Helen Donaldson <hcd@portlandmaine.gov>

Coastal Pharmacy sign application

Nell Donaldson
City of Portland Planning Division
874-8723
hcd@portlandmaine.gov

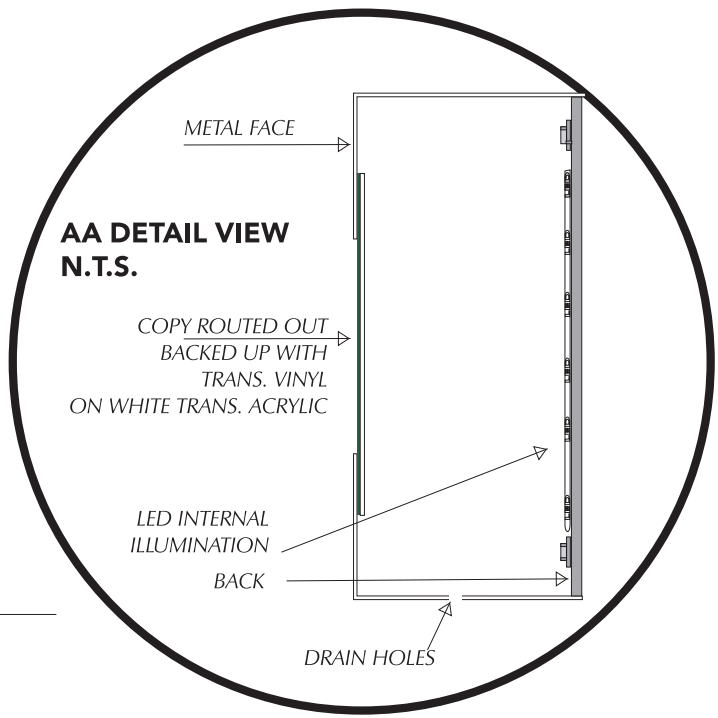
First, Ann has looked at the plans you provided and has requested more information on overall square footage on the sign that you're now proposing for the Marginal Way frontage. That sign can't exceed 94 SF.

Second, as for the box element which you raised questions about, I have spoken with the city's Urban Designer and others in planning who have been involved in the interpretation of the B-7 design guidelines for signs. As I mentioned above, individual, internally-illuminated letters are technically prohibited, as are box signs. We have made a conscious effort in recent reviews to draw a distinction between box signs (which read as boxes during the daytime, when unlit) and individual letters. We have recently required new sign applicants on Marginal Way to revise these portions of their signs to include a backer panel with individual letters.

Assuming the square footage works, both the individual, internally-illuminated letters and the box element of the sign would need waivers. We have recently required an applicant who proposed a very similar box element on Marginal Way to use a backer panel with individual, internally-illuminated letters.

Have you investigated the option of re-using the 'Coastal' element of the sign but replacing the box element with a backer panel with individual letters? I spoke to Cassi Brooks yesterday about this.

I spoke to folks here and am not seeing a way to approve the box element, even if it is painted to match the building color. As I mentioned before, we have worked hard in recent approvals to uphold the prohibition on box signs. Is there any way to externally illuminate the "Wellness & Pharmacy" portion of the sign?

The B-7 design guidelines state that "standard internally-illuminated signs - including plastic faced, box-type signs and individual plastic letters - shall be prohibited. Acceptable forms of internal illumination may include halo-lit signs and die-cut metal sign panels that illuminate individual letters and symbols only."

Again, we have granted a waiver for the individual letters in the past, so this is just about the box.

As for the redesign of the sign, just for the record, can you produce a section of the 'Pharmacy & Wellness' portion of the sign?

Can you easily send a section of the redesigned portion of the sign, just for the record?

Please see attached revised drawing for Coastal Pharmacy sign. We will replace the current acrylic face box sign with a routed metal face where only the lettering lights at night. Please let me know if there is anything for the waiver of the Coastal letters that I need to fill out.

I did some bribing in our design room.... Attached is the drawing showing a section of the new metal face with routed lit copy for the box portion of the sign. Please let me know that we have final approval on this.

I think, technically speaking, that should work. I will put this plan in our file and sign off on the waiver review.
